Defence Infrastructure Organisation

12 July 2024

Section 42 of the Planning Act 2008 ('the Act') and Regulations 11 and 13 of the Infrastructure Planning (Environmental Impact Assessment) Regulations 2017 ('the 2017 Regulations')

I write to provide the MOD safeguarding position on information provided in the Preliminary Environmental Information Report (PEIR) Statement.

DRAWING NUMBER: **13.3**

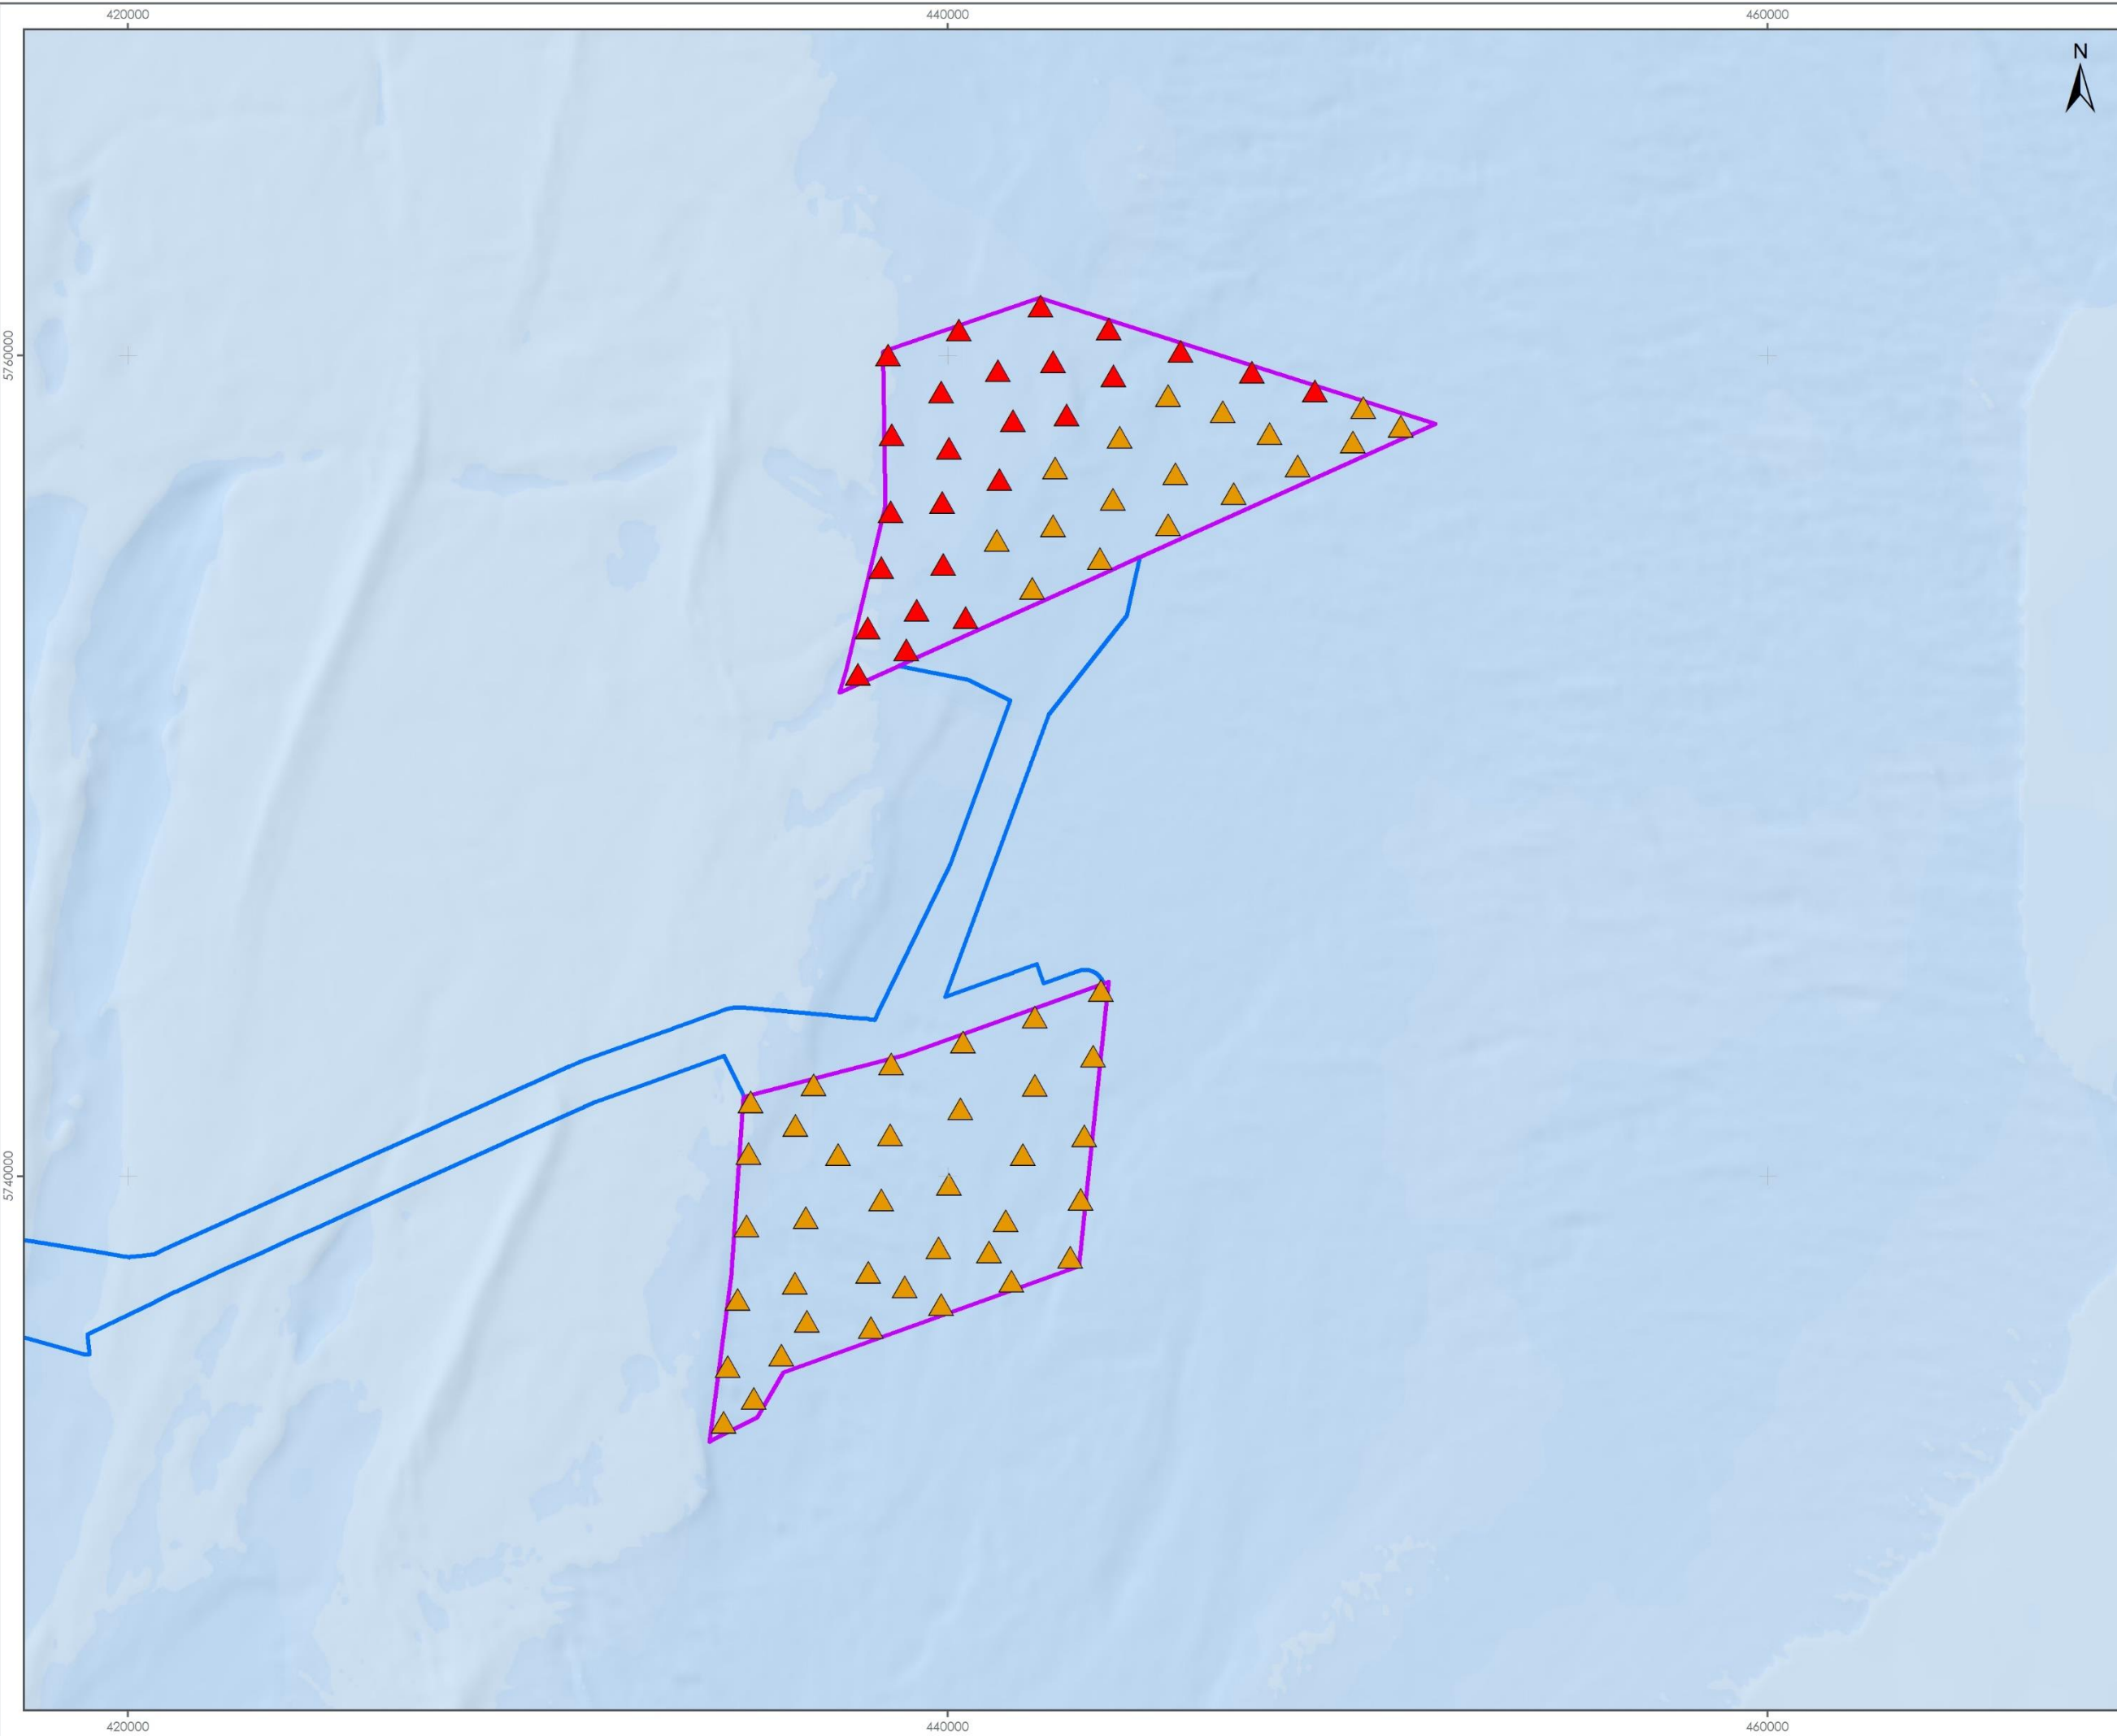
Within section 13.6.11 and 13.6.12, it is recognised that the turbines would be visible and detected by the AD radars at RRH Trimmingham and RRH Neatishead.

The MOD has undertaken an assessment based on 79 wind turbines at 420m to tip height MHWS using the Rochdale Envelope boundary co-ordinates. Turbines within both the southern and northern array areas will be detectable to the AD Radar at RRH Neatishead. The impact of the turbines on the AD radar at RRH Neatishead will therefore need to be addressed through a suitable technical mitigation solution. It is the applicant's responsibility to provide a suitable technical mitigation solution to the MOD.

Mitigation to address the impact of the development on the AD Radar at RRH Neatishead is considered at 13.16.4. It is stated that engagement with the MOD will continue throughout the application process, this is welcomed.
